Rosefield Solar Farm

Applicant's Response to Deadline 4 Submissions

EN010158/APP/8.32
Revision 01
Deadline 5
July 2026
Rosefield Energyfarm Limited

Annex 3a – Auger and Pit Location Map (ADAS)

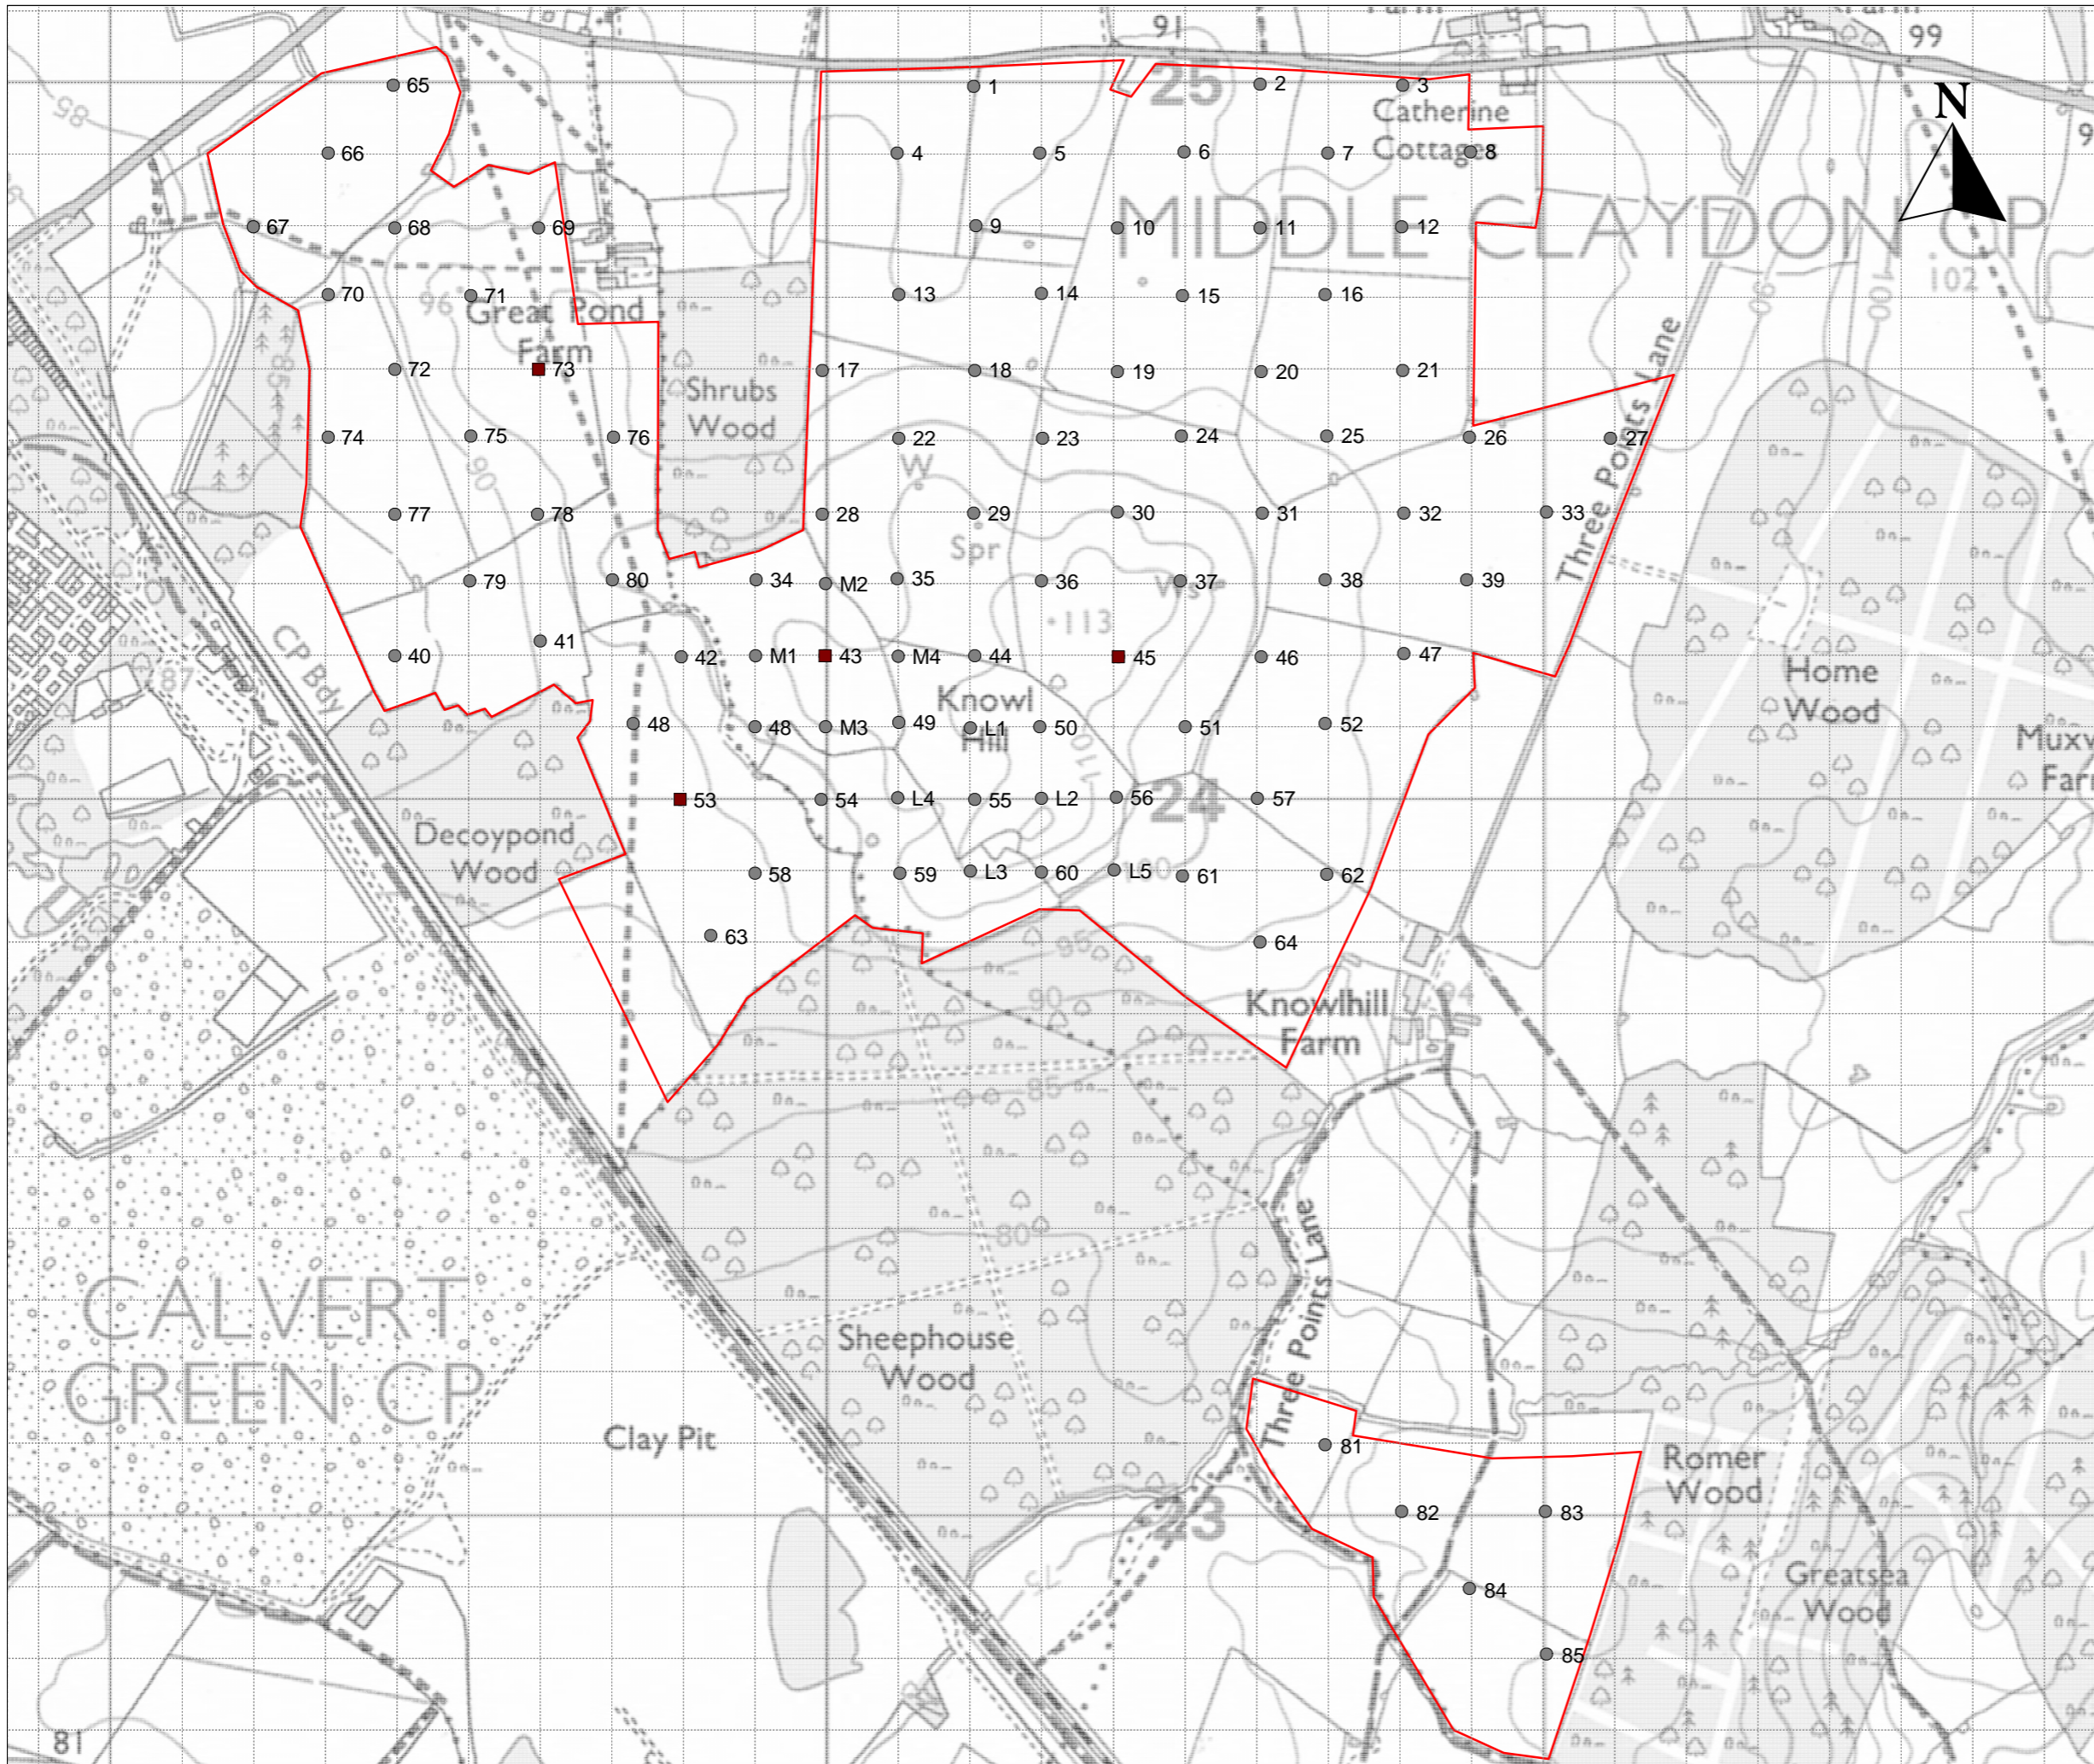
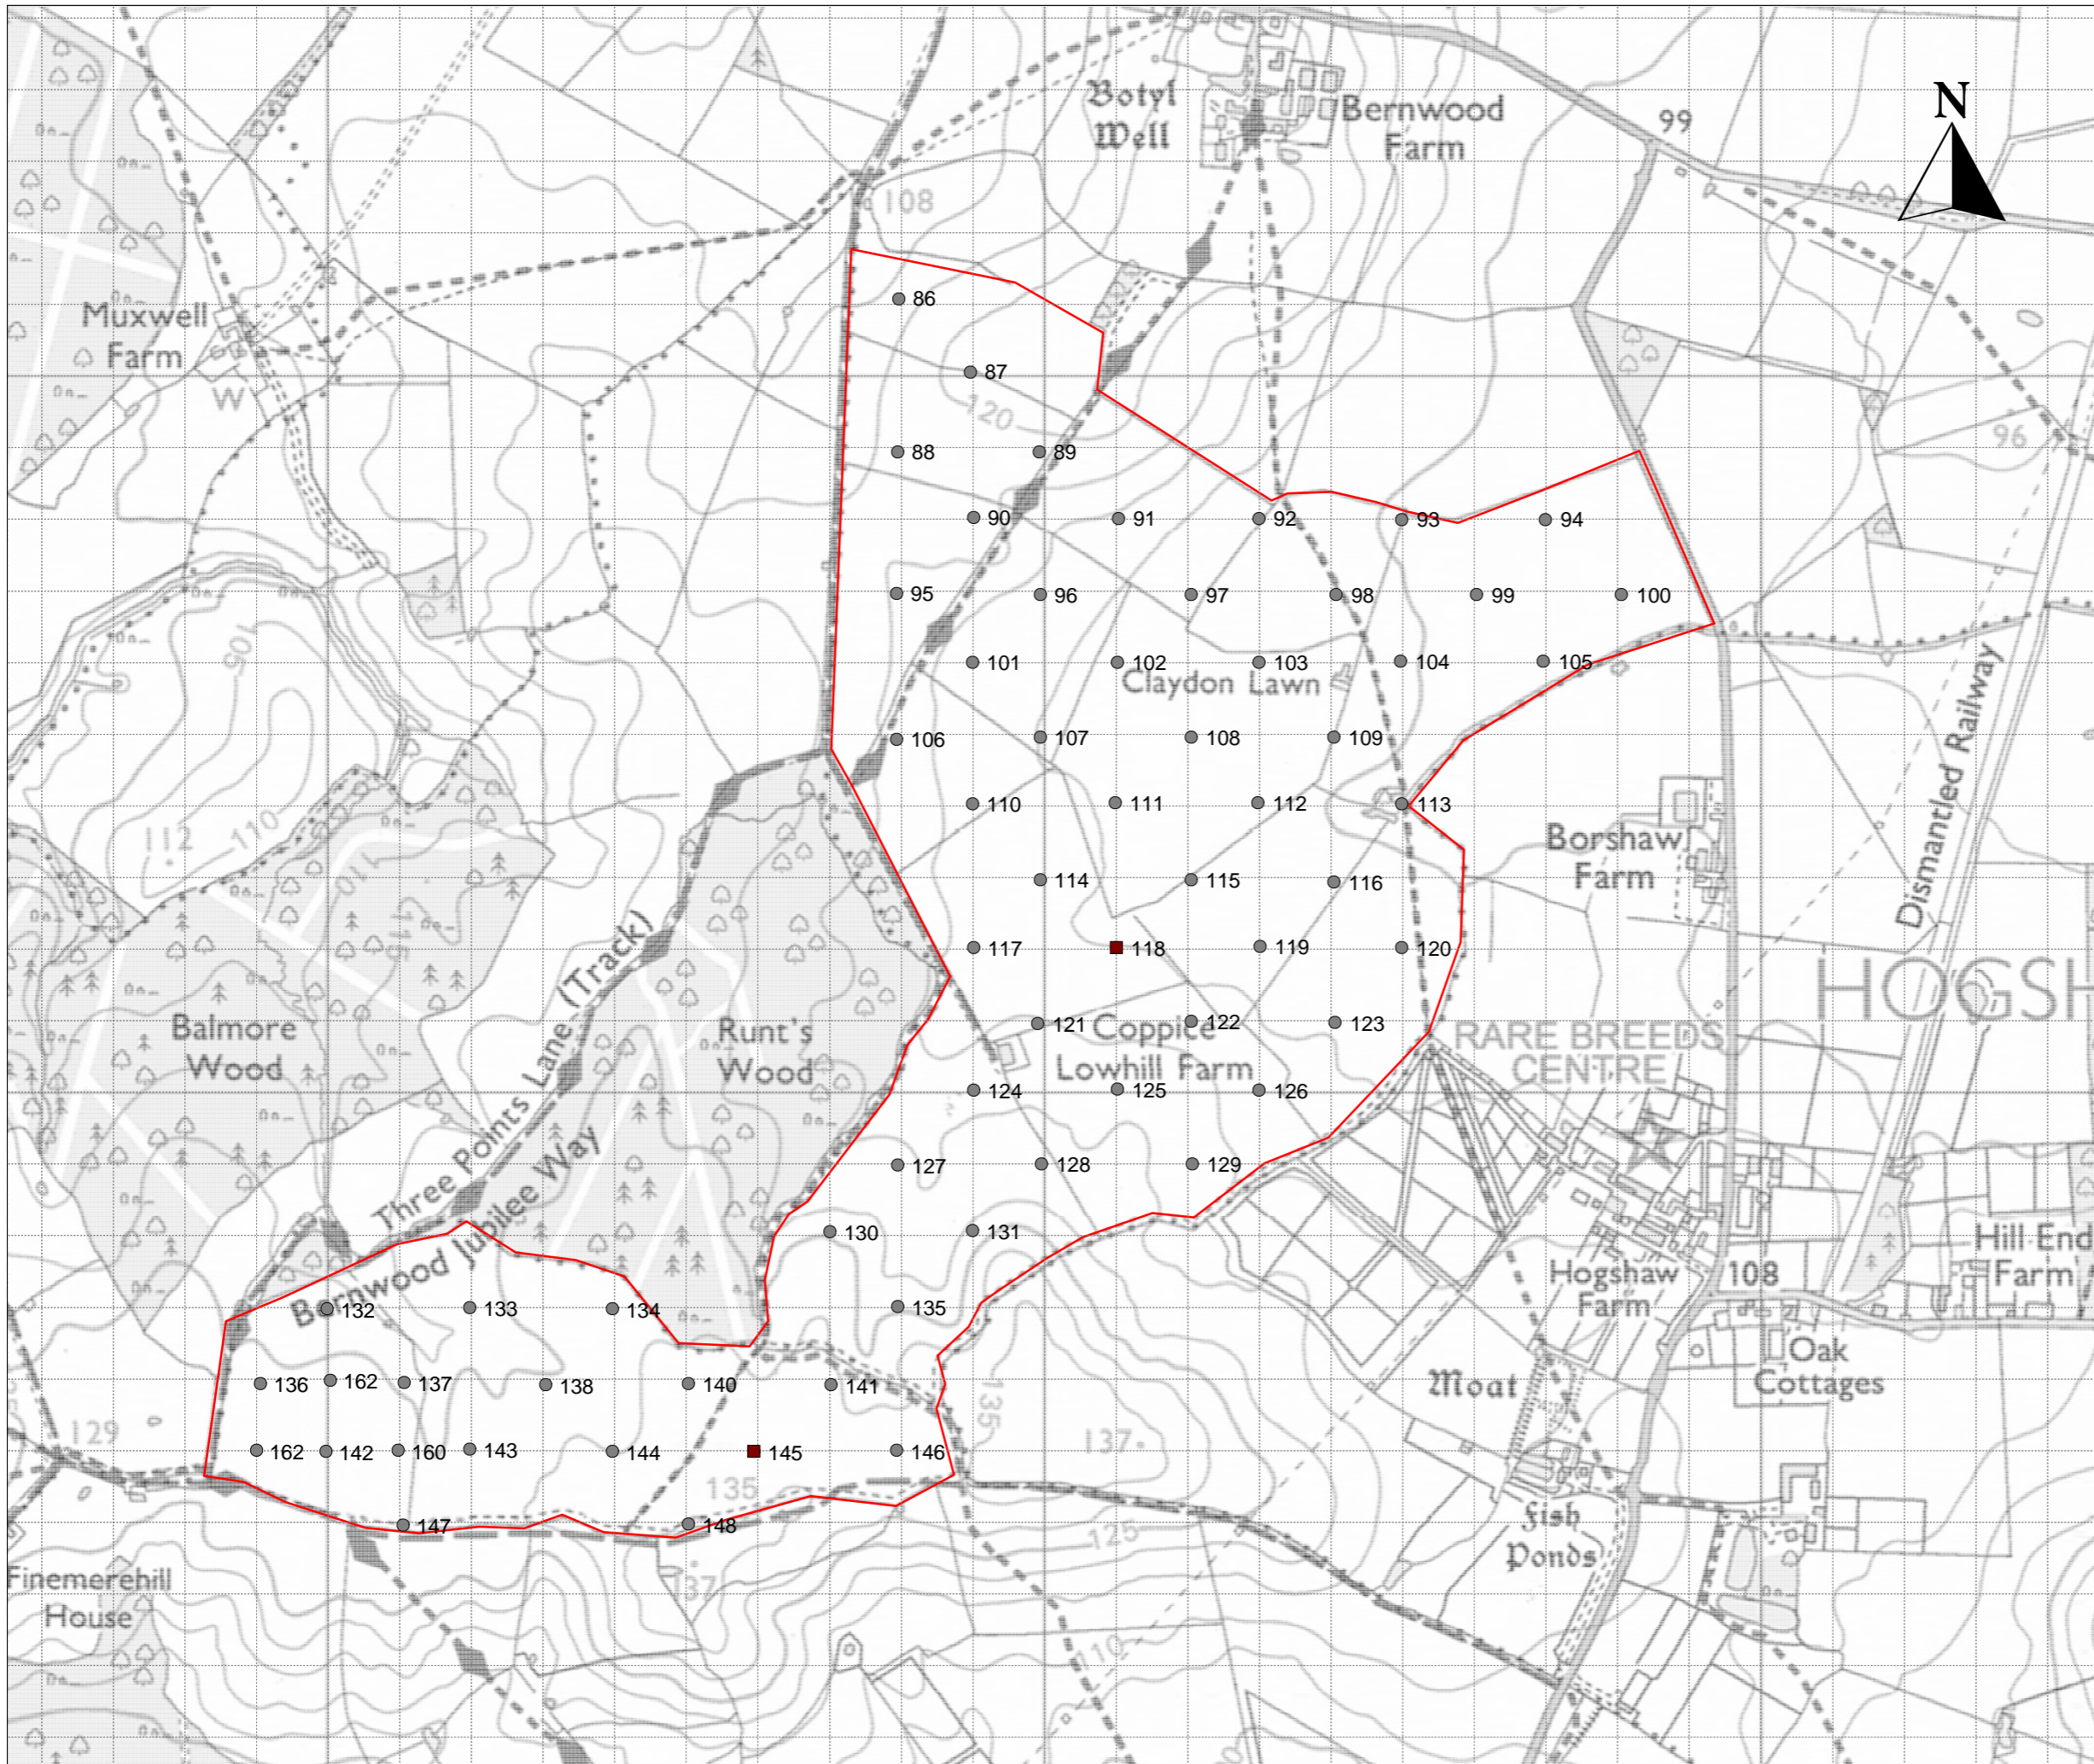
3.39	John Philip Claridge [REP4-105], Page 2	Comment noting that point 45 within the Agricultural Land Classification Report is marked as being surveyed, though the party considers this to be untrue and misleading. Comment noting that the Report does not accurately reflect the party's understanding of the land within their holding. Further comment that the soil type of the party's land to be Grade 3a, not Grade 3b.	Point 45 is a pit that was dug as part of the ALC survey conducted by LRA in January 2023, the results of which are presented in ES Volume 4, Appendix 12.1: Agricultural Land Classification Report [EN010158/APP/6.4.3] to assign the land an ALC Grading. Surveyors began discussions with the Claydon Estate regarding the ALC surveys in September 2022, and met Mr Claridge on-site in person on 23 January 2023. Access was granted for the land east of Knowl Hill, including pit 45 and auger points 47,52,46, 51 & 64 (those contested by Mr Claridge) on 24 and 25 of January 2023. Annex 3a in ES Volume 4, Appendix 12.1: Agricultural Land Classification Report [EN010158/APP/6.4.3] mistakenly shows four soil pits, including pit 45 mentioned by Mr

Ref.	Submission Reference and Identifier	Summary Position	Applicant's Response
			Claridge, as having been dug by RSK ADAS. These pits were actually dug by LRA, as is correctly shown in Annex 3b. Annex 3a, showing the RSK ADAS auger and pit locations, has been updated at Deadline 5 to remove reference to pits dug by LRA. The ALC Grade 3b was assigned in accordance with the 1988 MAFF guidance 'Agricultural Land Classification for England and Wales: Revised Guidelines and Criteria for Grading the Quality of Agricultural Land'. Auger boring logs in Annex 4a of ES Volume 4, Appendix 12.1: Agricultural Land Classification Report [EN010158/APP/6.4.3] show land in this area to have a gleyed slowly permeable layer within 40cm. Combined with the Site field capacity days of 136-142, as specified in Table 4.1, this places the soils in Wetness Class IV. Clay and Clay loam soils in Wetness Class IV are assigned a Grade according to wetness of 3b, which in this instance is the overall ALC Grade for this area of land.
